Tel: 01903 737756
Email: planning@arun.gov.uk
www.arun.gov.uk/planning
Please ask for: Jonny Cooper
Email: jonny.cooper@arun.gov.uk
Telephone: 01903 737532
Our Ref: WA/52/25/PL
Your Ref:
Date: 26th June 2025

Application for Planning Permission

Development: Removal of residential caravan and erection of 1 No. self-build dwelling. This application is In CIL Zone 3 and is CIL liable.

Location: Cherry Tree Nursery Eastergate Lane Walberton BN18 0BA

CLIENT	PROJECT	TITLE	STATUS	DRAWN BY	REVIEWED BY
JAMES COLE	CHERRY TREE NURSERY EASTERGATE LANE WALBERTON	PROPOSED FLOOR PLANS AND ELEVATIONS	PLANNING	SJ	SJ
DATE	SCALE	DRAWING NUMBER			
05.08.2025	1:100@A2	4

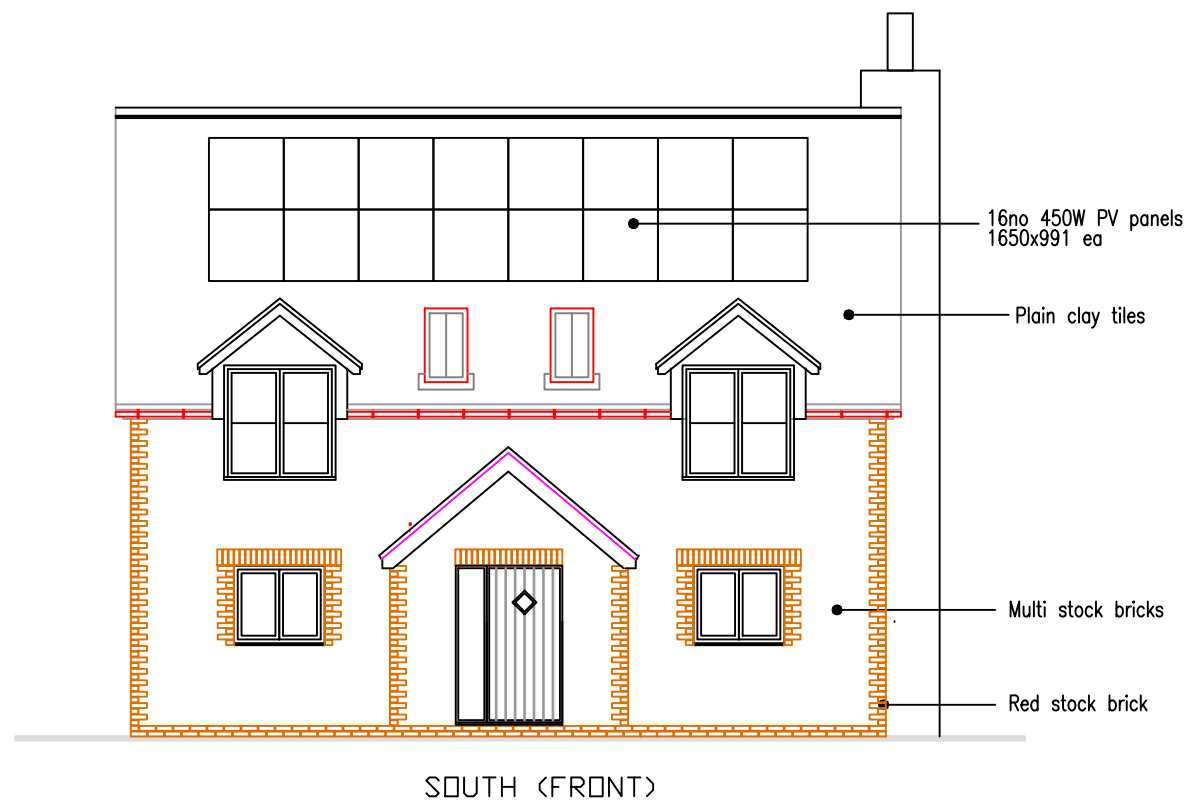
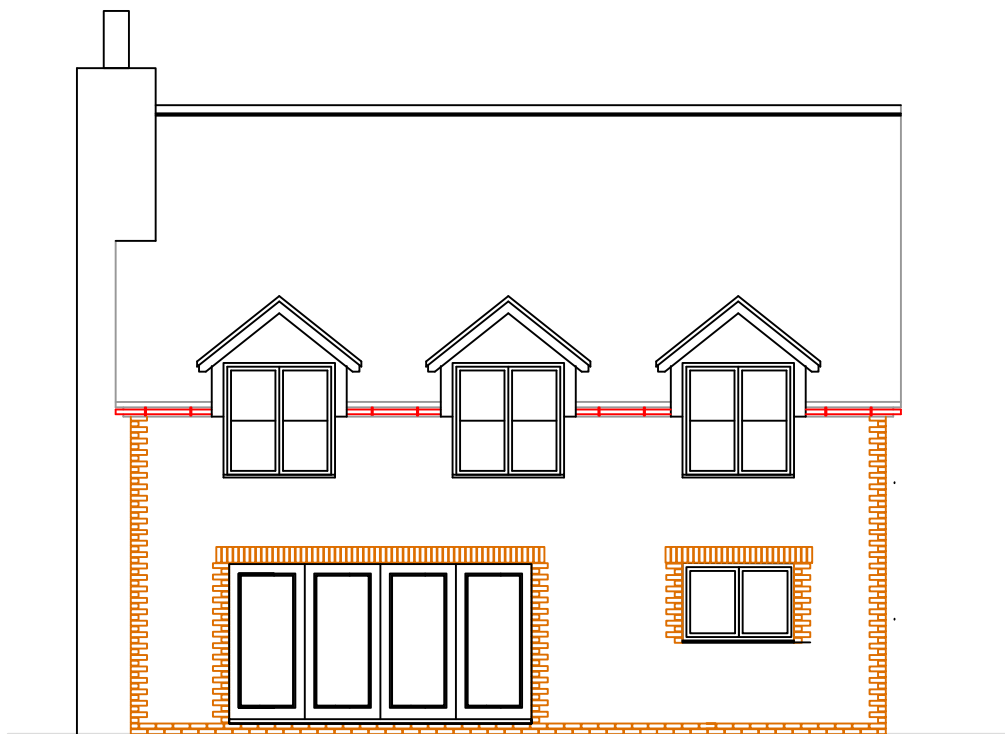
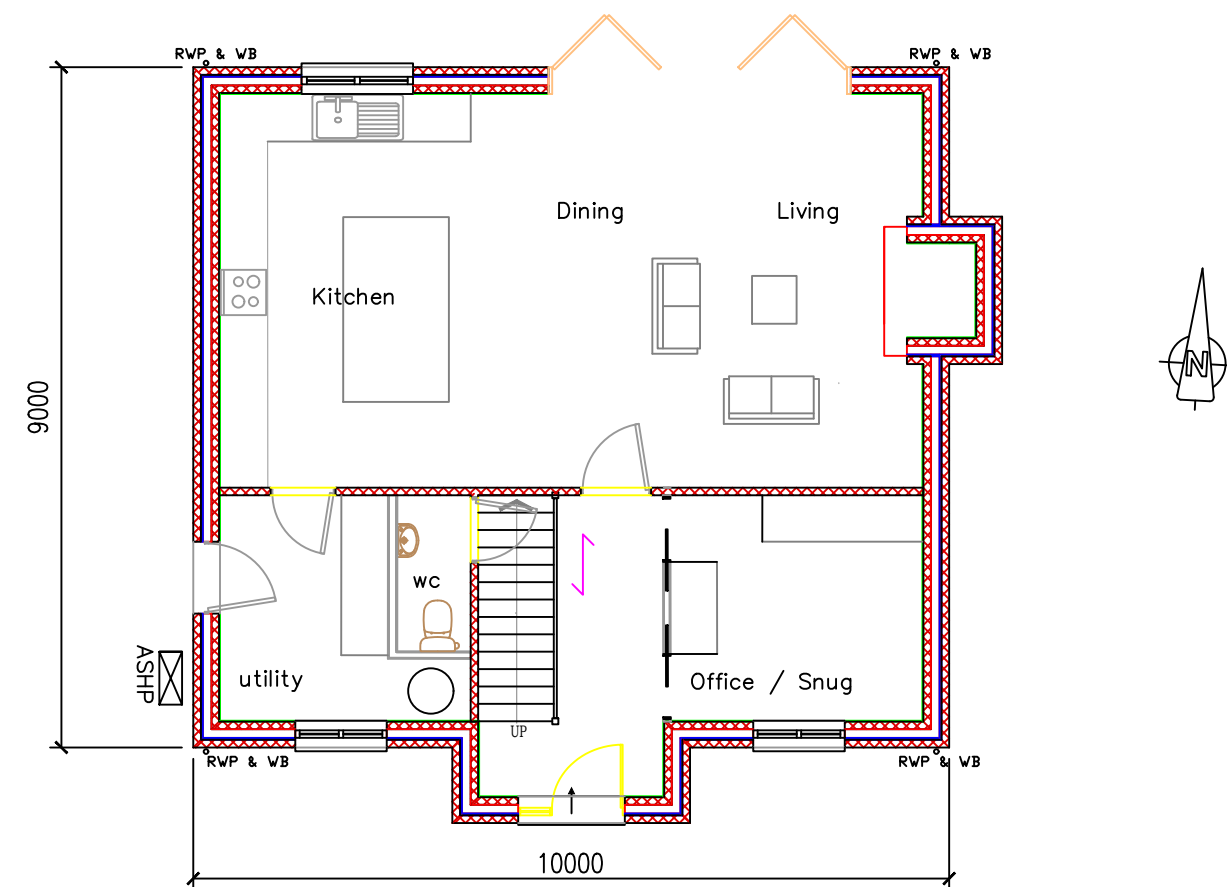
The window serving the kitchen scales at 1.1m on the proposed elevation, but at 1.45 m on the proposed floor plans. Please amend accordingly and resubmit.

Roof

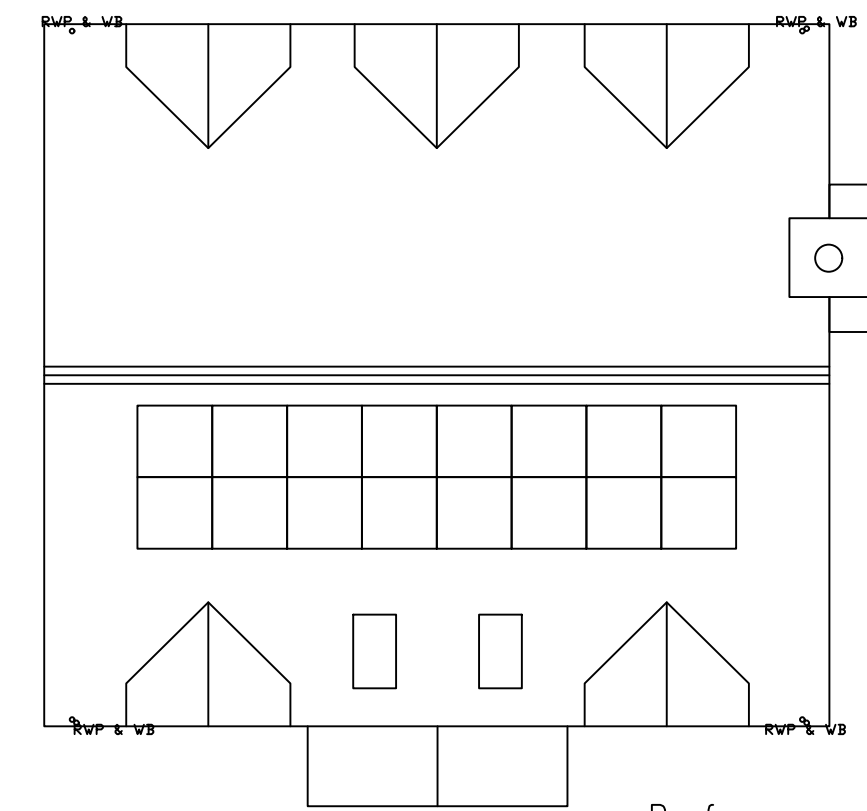
Please include the solar panels on the proposed roof plan.
